# Community Design Solutions

May 21, 2025

## RE: Comment Responses to DFT Comments Issued on 4/16/2025 for PR-2020-004098

The following are comment responses in response to the DFT comments issued for the post-EPC site plan signoff by DFT staff for PR-2020-004098. The comments were issued on the DFT hearing on April 16, 2025. The comments have been copied below, and CDS's comment responses are provided in [blue](#).

NAME: P:\246101 Ashland Bridge and 86th\3. DWG\4. Exhibits\C-102 Utility Plan.dwg Plotted: Jan 08, 2025 10:54am

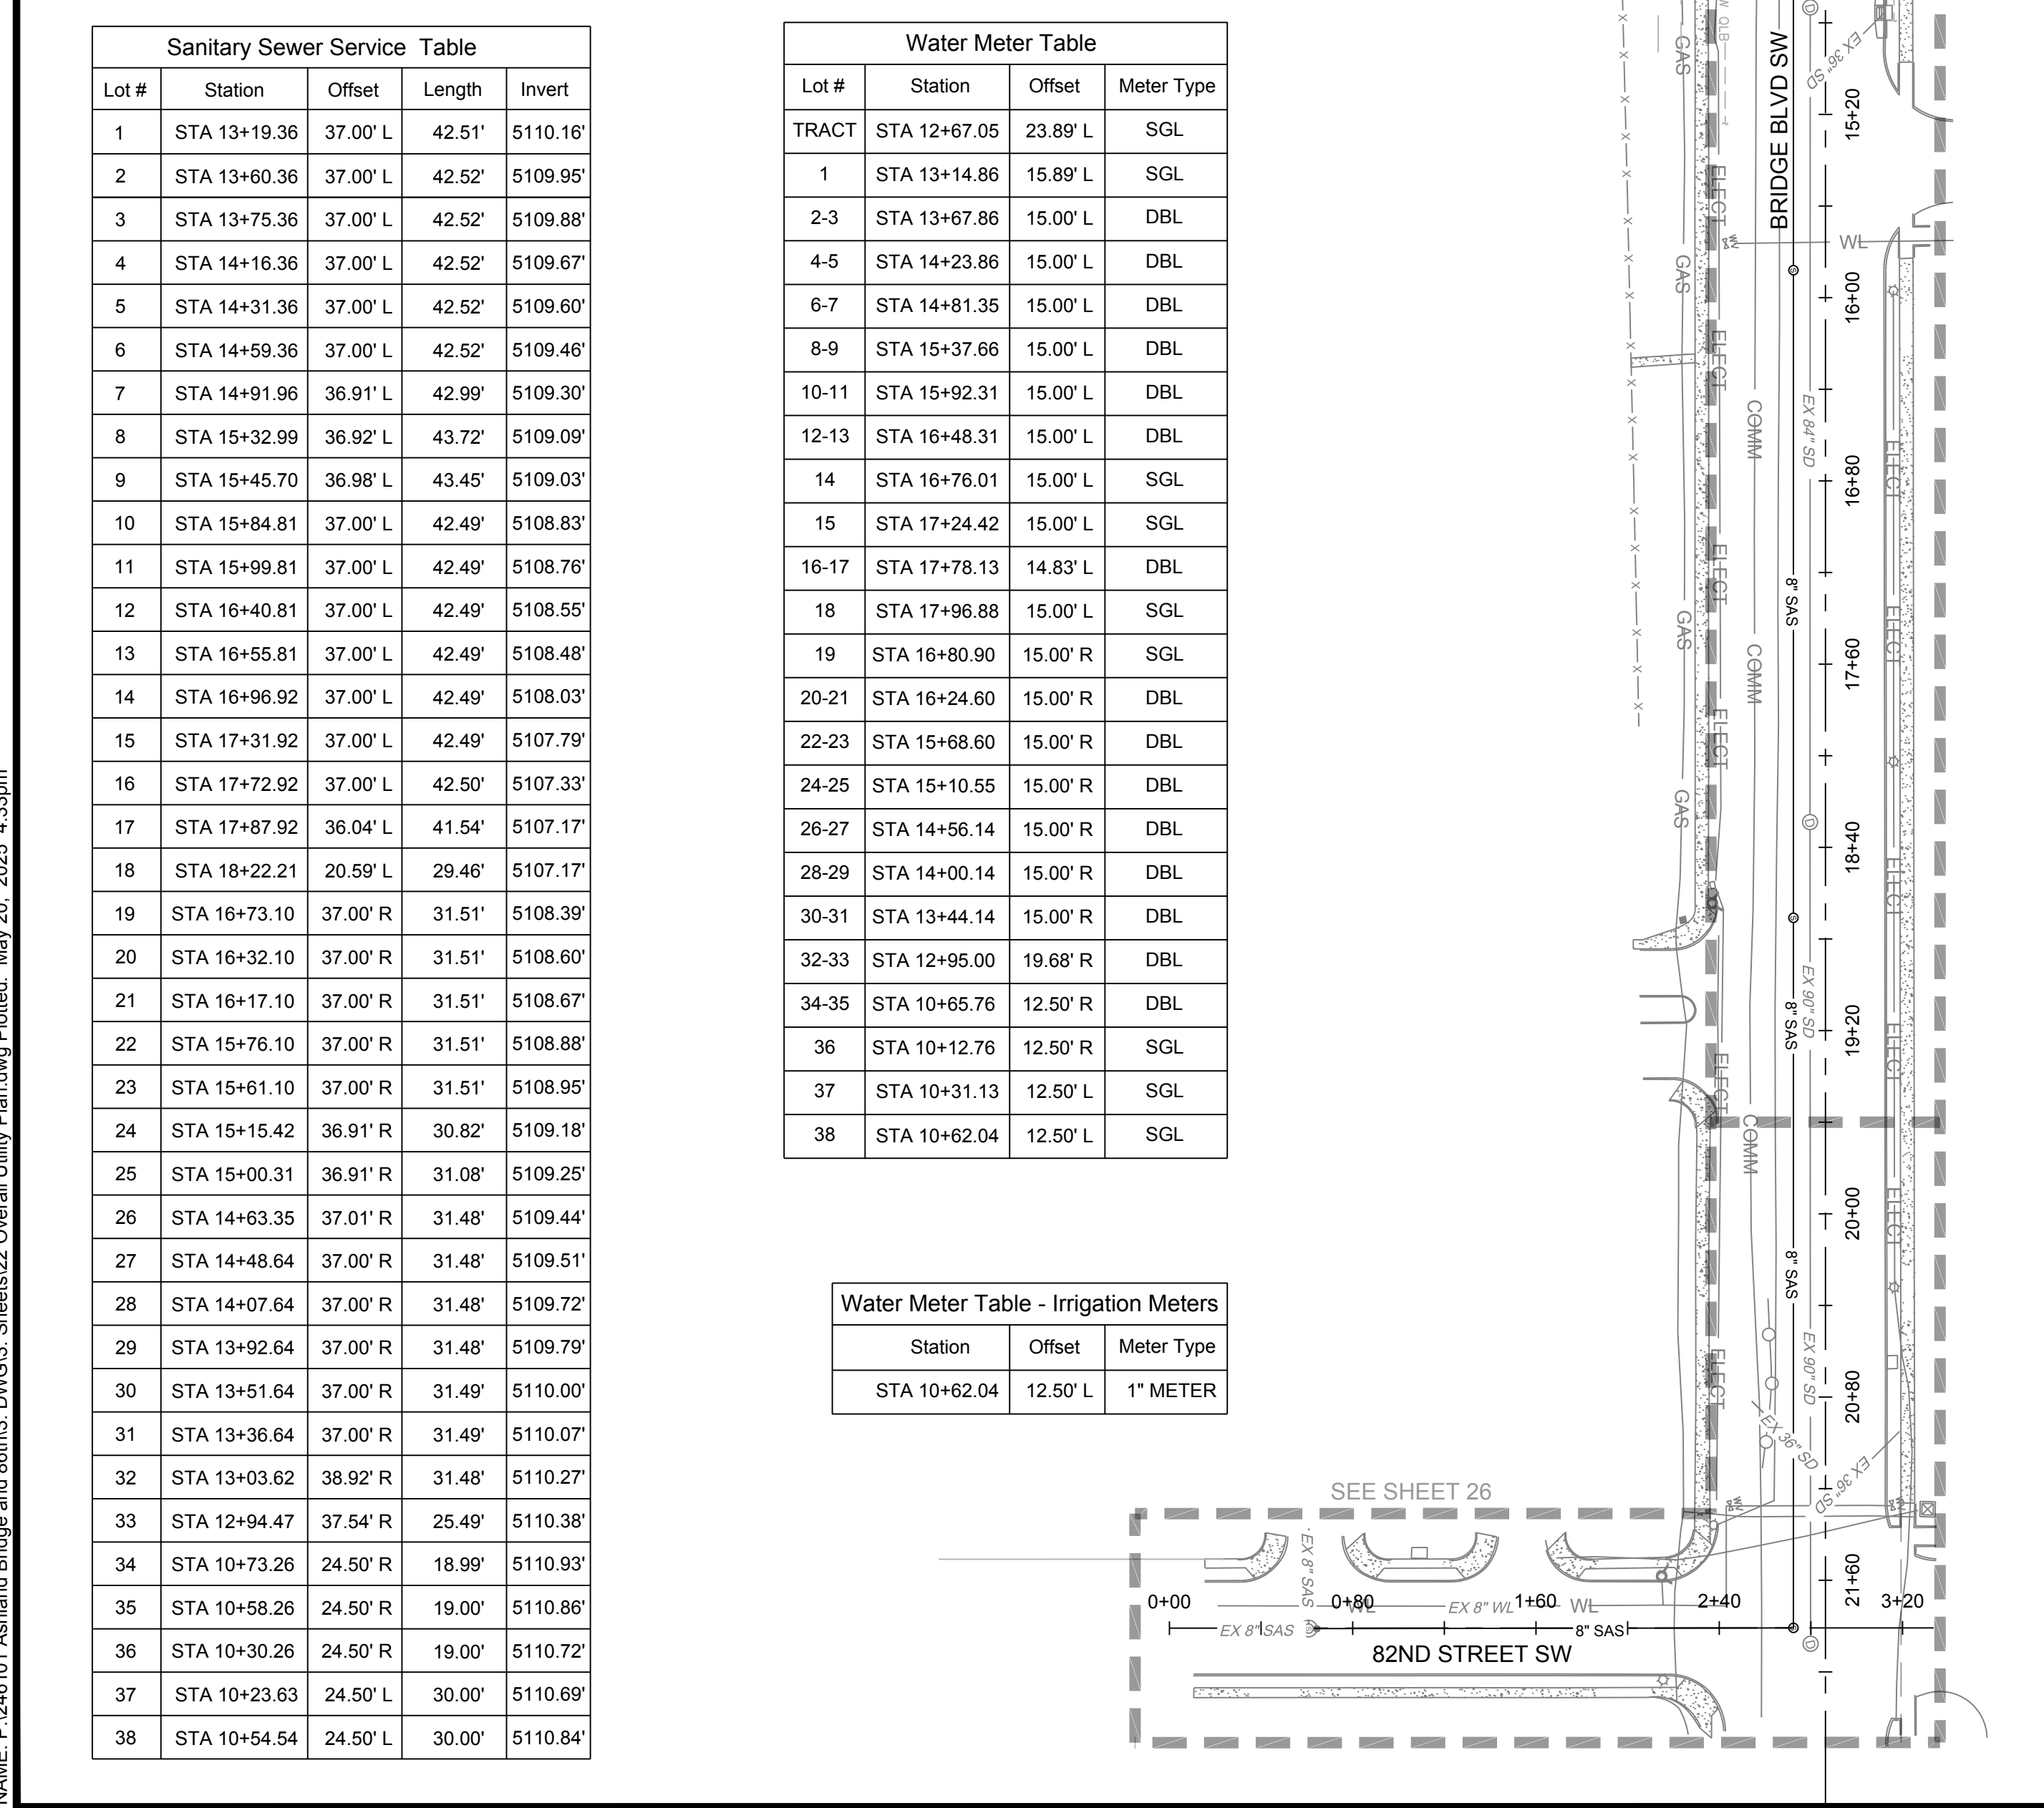
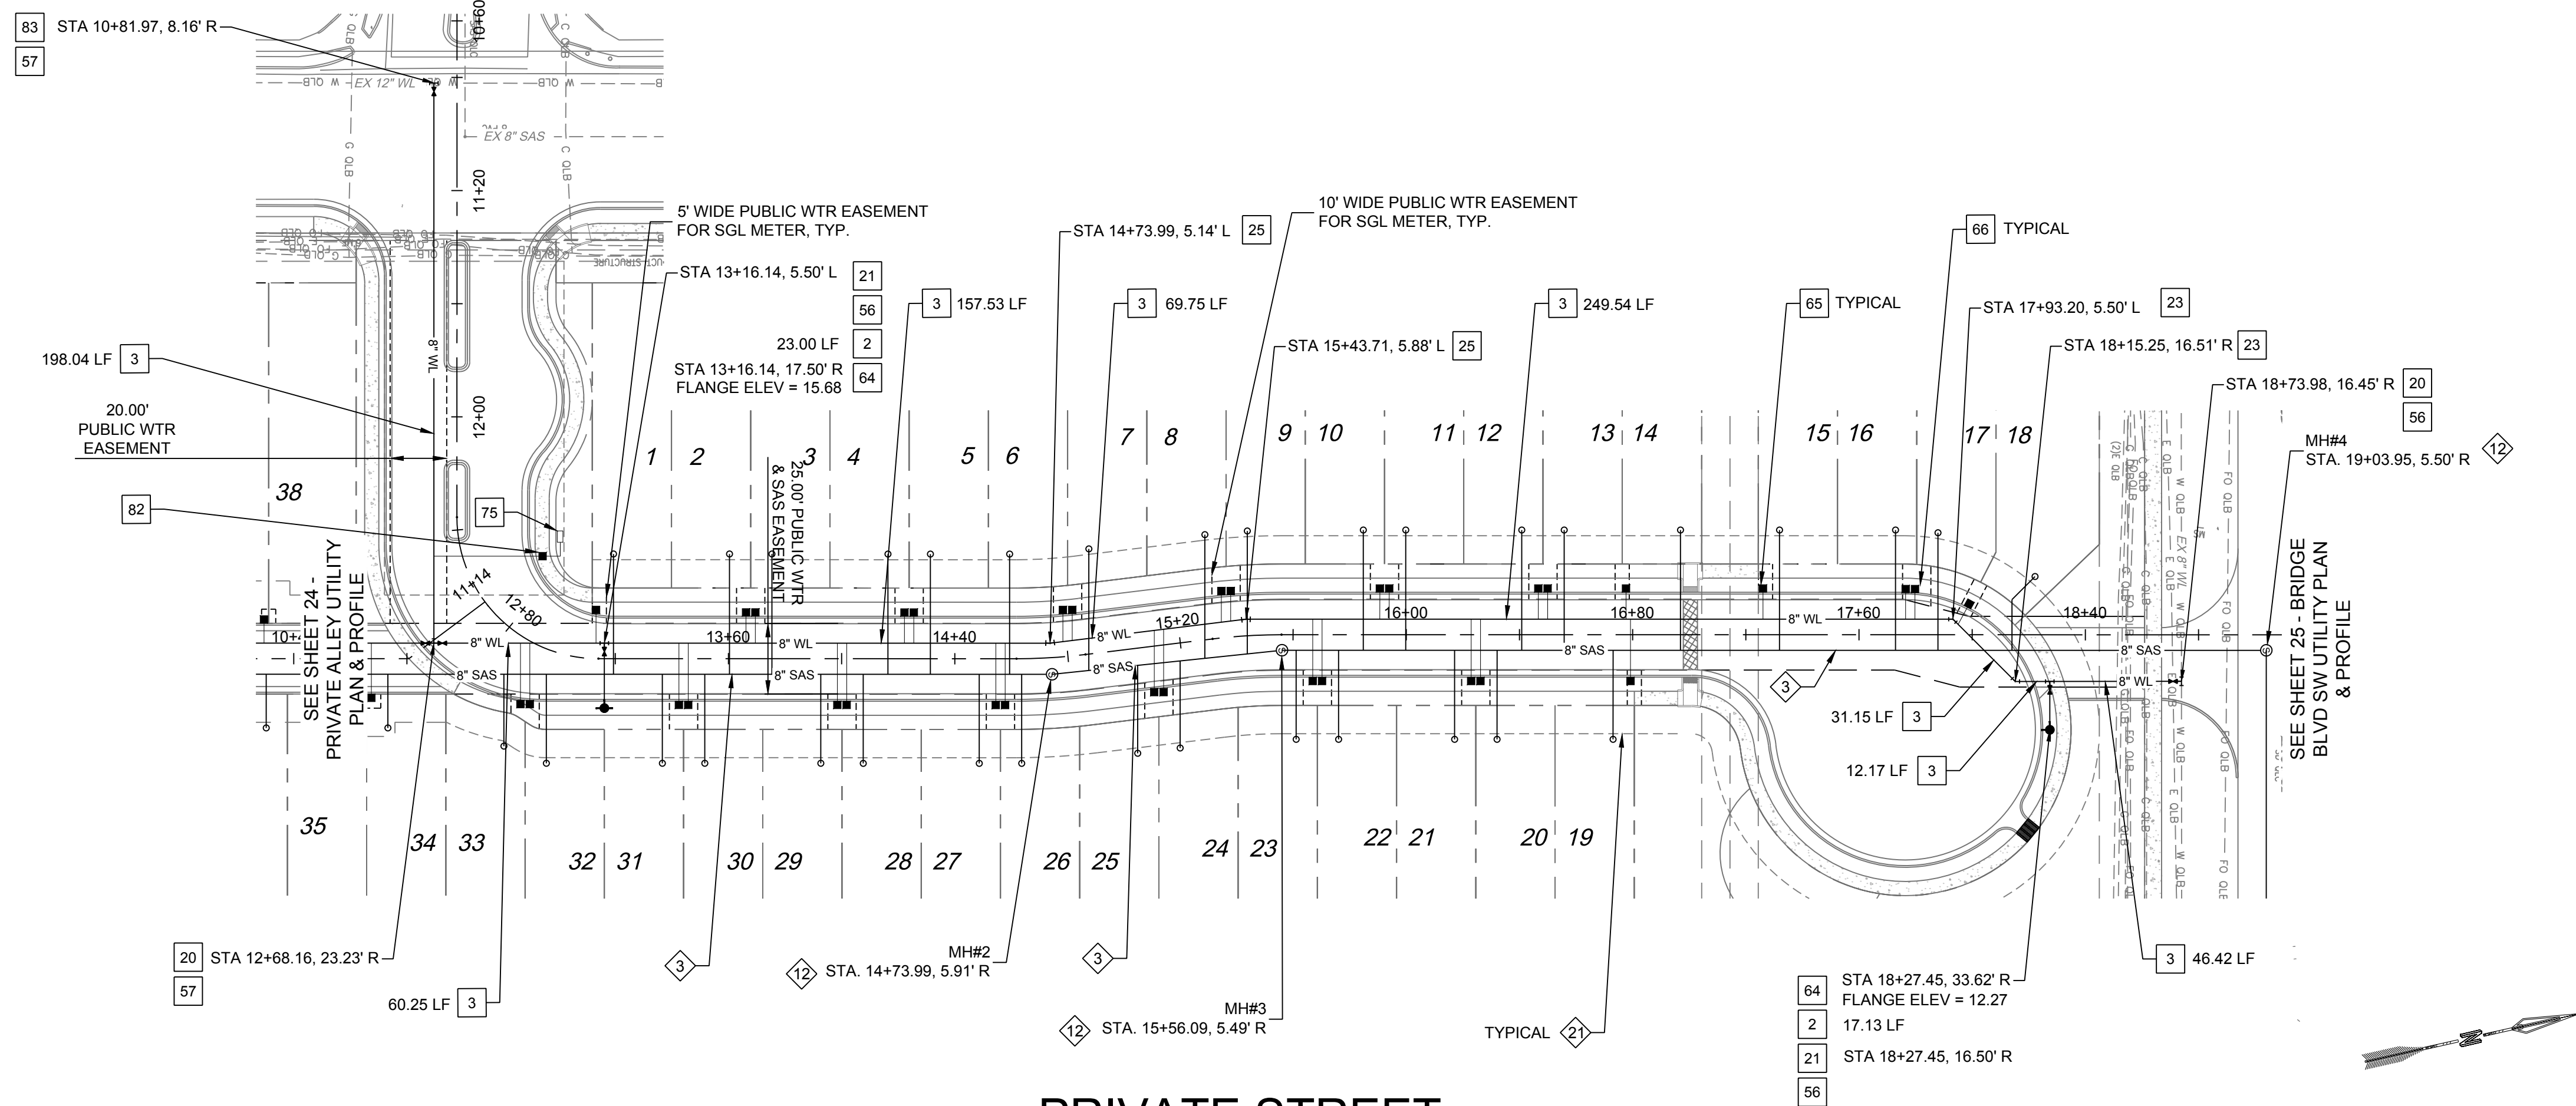
- i. [Not used](#).
    - ii. Dimension the public water and public sewer easements on the utility plan. [The updated utility plan contains the utility plans from the construction plans currently in review at DRC. Public water and public sewer easements are shown, labeled, and dimensioned.](#)

- vi. Show existing public water and public sanitary sewer mains and associated easements on the utility plan. The existing public 8-inch collector sewer line in Bridge Blvd is missing on the plan. Also, show the alignment of the developer-funded sanitary sewer line extension from the property to the existing public 8-inch sanitary collector line in 82nd St. [Done.](#)

- c. The proposed sanitary sewer line shows what to appear to be manholes at the flowline of the street (c&g). Manholes must not be placed within the flowline. [Plan has been revised to move manhole out of the street flowline.](#) Additionally the south end of the subdivision shows a proposed manhole potentially that appears to be abutting the perimeter of the site. Please ensure there is additional easement south of the manhole and that the Water Authority has access to the manhole and no cars can be placed on top of the manhole. A large Vector Truck must be able to access all proposed manholes. [Plan has been revised to move the manhole further into the alley and away from the perimeter of the site.](#)
